## Appeal Decision

**Appeal Ref: APP/T2350/Y/23/3317331**

**32 Parson Lane, Lancashire, Clitheroe, BB7 2JP**

- The appeal is made under section 20 of the Planning (Listed Buildings and Conservation Areas) Act 1990 against a refusal to grant listed building consent.
  - The appeal is made by Mrs Analisa Smith against the decision of Ribble Valley Borough Council.
  - The application Ref 3/2022/0778, dated 11 August 2022, was refused by notice dated 17 October 2022.
  - The works proposed are described as 'proposed creation of ground floor WC with associated drainage and ventilation.'
-

PROPOSED GROUND FLOOR PLAN - OPTION 01
SCALE 1:50

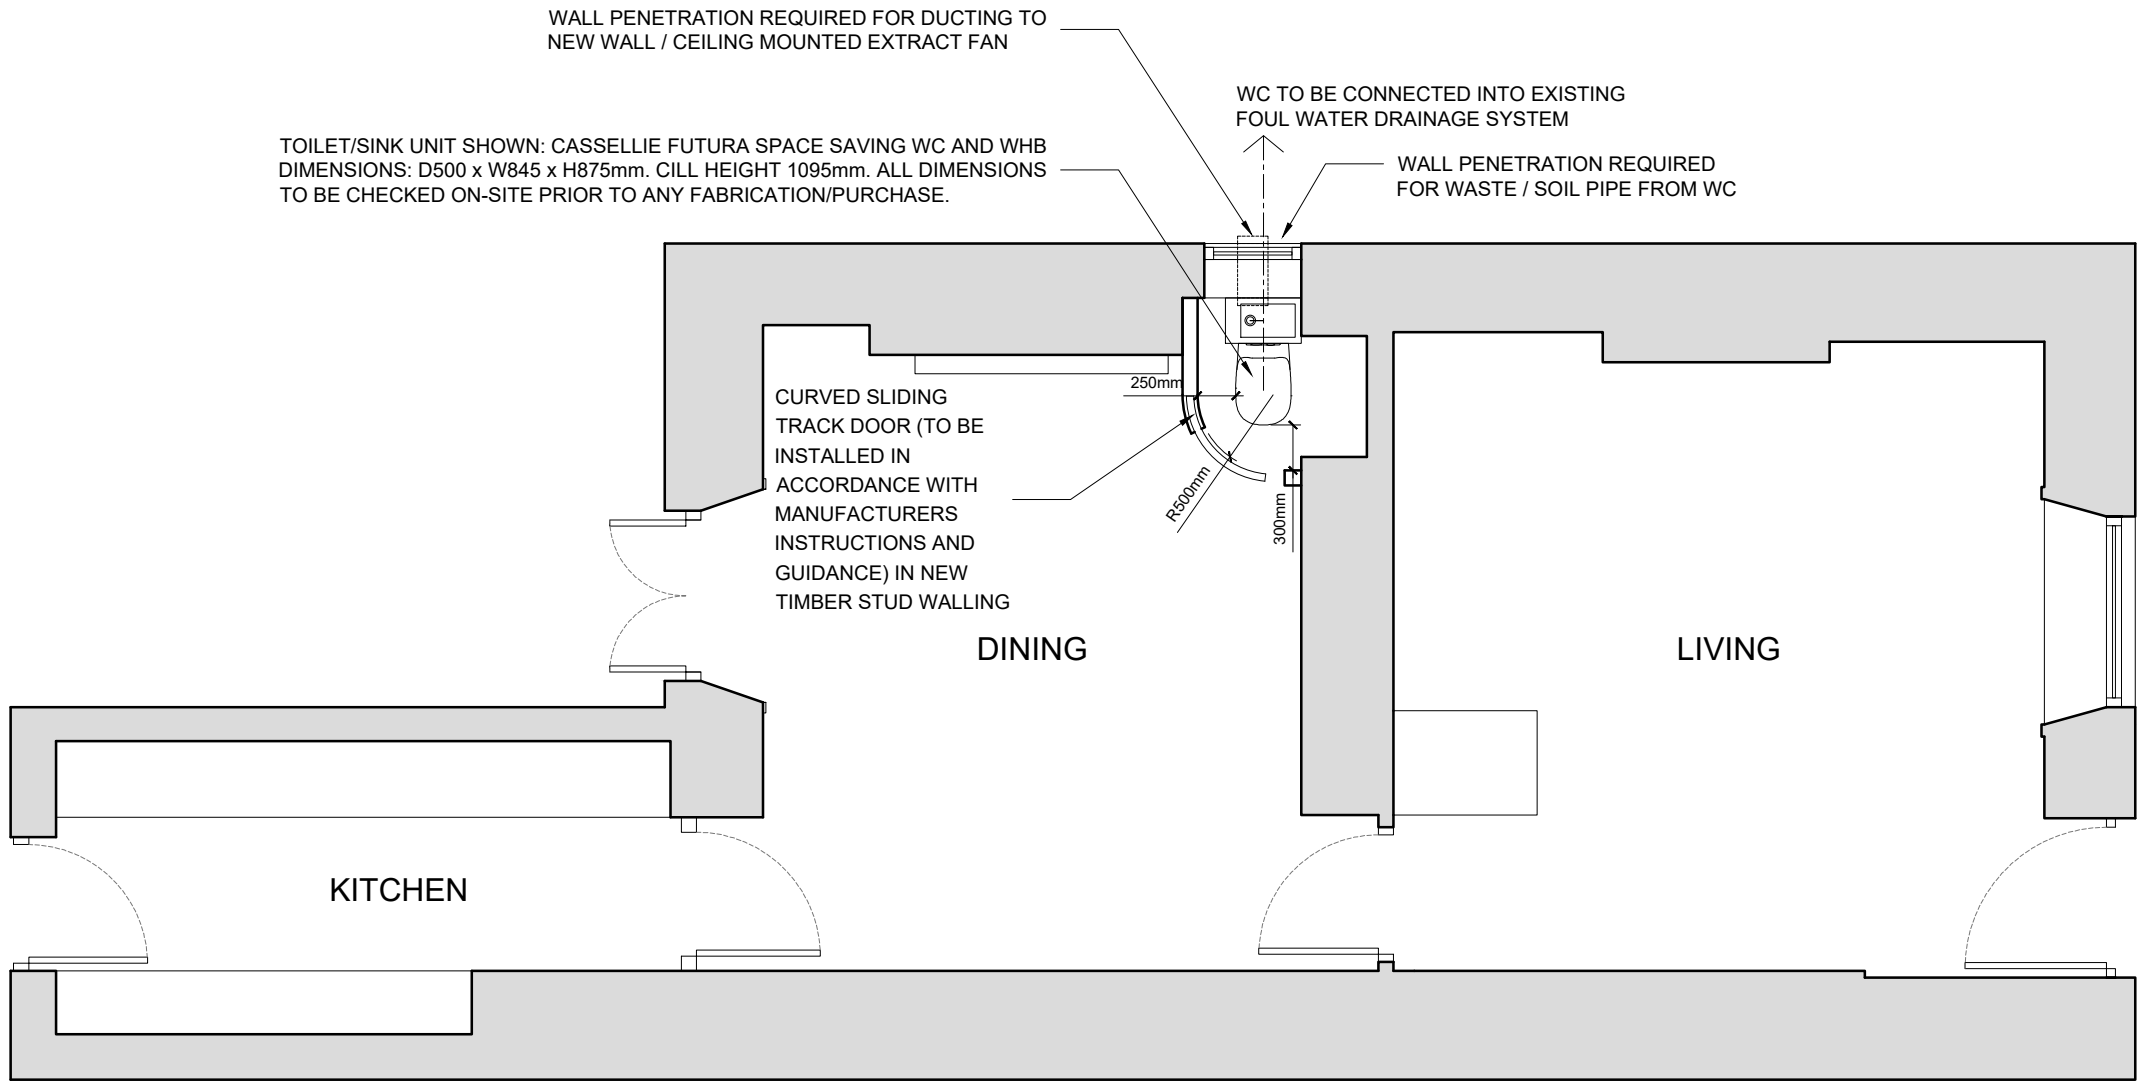
9. The works concern the creation of a space saving WC and hand basin in the corner of the ground floor rear dining room. This would be installed in the recess adjoining the fireplace and an integral cupboard which is located in the dividing wall between the dining room and the front living room. The room's flank window immediately adjacent to the fireplace would be incorporated into the new WC to allow light and ventilation. A full height curved enclosure would be provided. This would be built using stud timber construction and a sliding track. The works would be reversible in that the partitions and the toilet/sink could be removed.

11. Nevertheless, despite these factors, it remains that in practical terms the proposed works would subdivide the space and alter the size and arrangement of the dining room. They would compromise the distinctive proportions of the rectangular room which are mirrored in the front room, and are intrinsic to the building's character. In doing so the works would undermine the historic form and layout of the property and erode its characteristic simple two cell floorplan.

12. Whilst no historic ceiling cornices would be affected, the property's flank window would be concealed from view from within the dining room. The recesses in the walls surrounding the window and the chimney breast, as well as arising from the cupboard feature, would also be lost. These pleasing details would be obscured and the internal rhythm and relief of the walls in the dining room eroded. Whilst the existing fireplace is a more modern gas range, the WC would nevertheless occupy a close and distracting juxtaposition in relation to the historic feature of the chimney breast.

PROPOSED DINING ROOM/ WC SECTION
SCALE 1:20

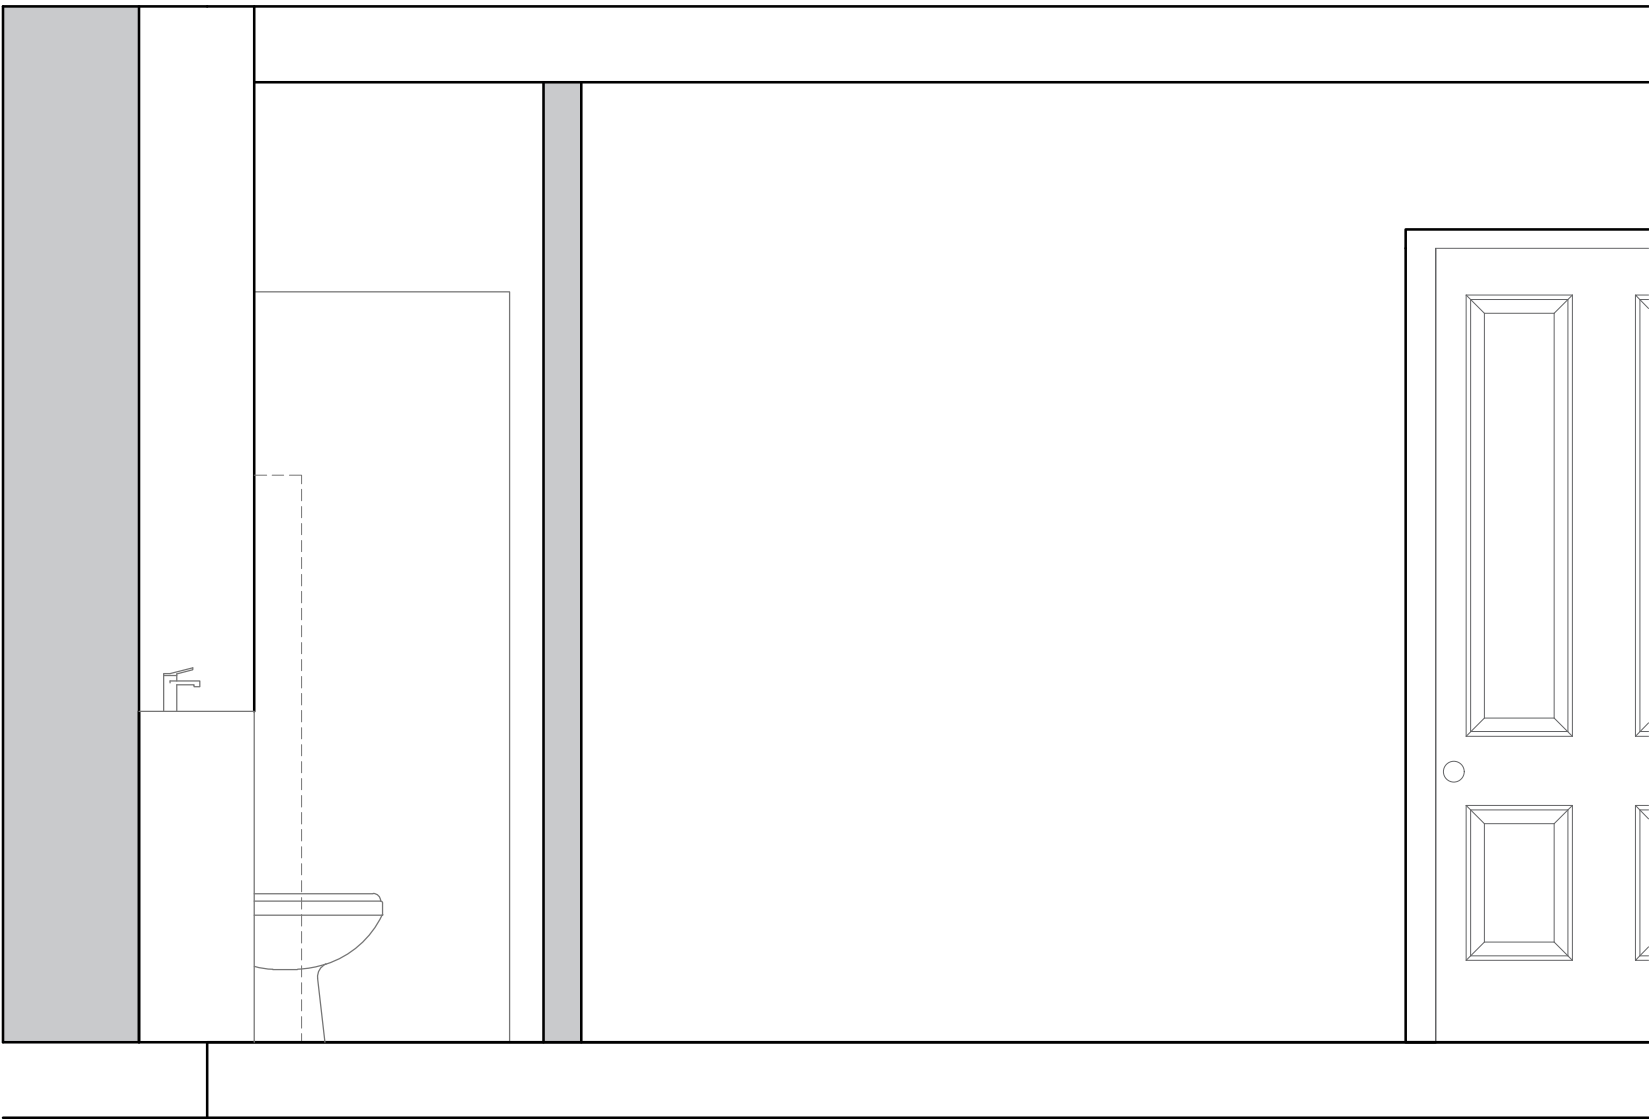
13. Additionally, the proposed works includes a 100mm wall aperture for a waste pipe and another for an extractor fan duct. These are required by the building regulations and would result in a very small loss of historic fabric. Additionally a limited extent of stud walling would be fixed to the existing wall.
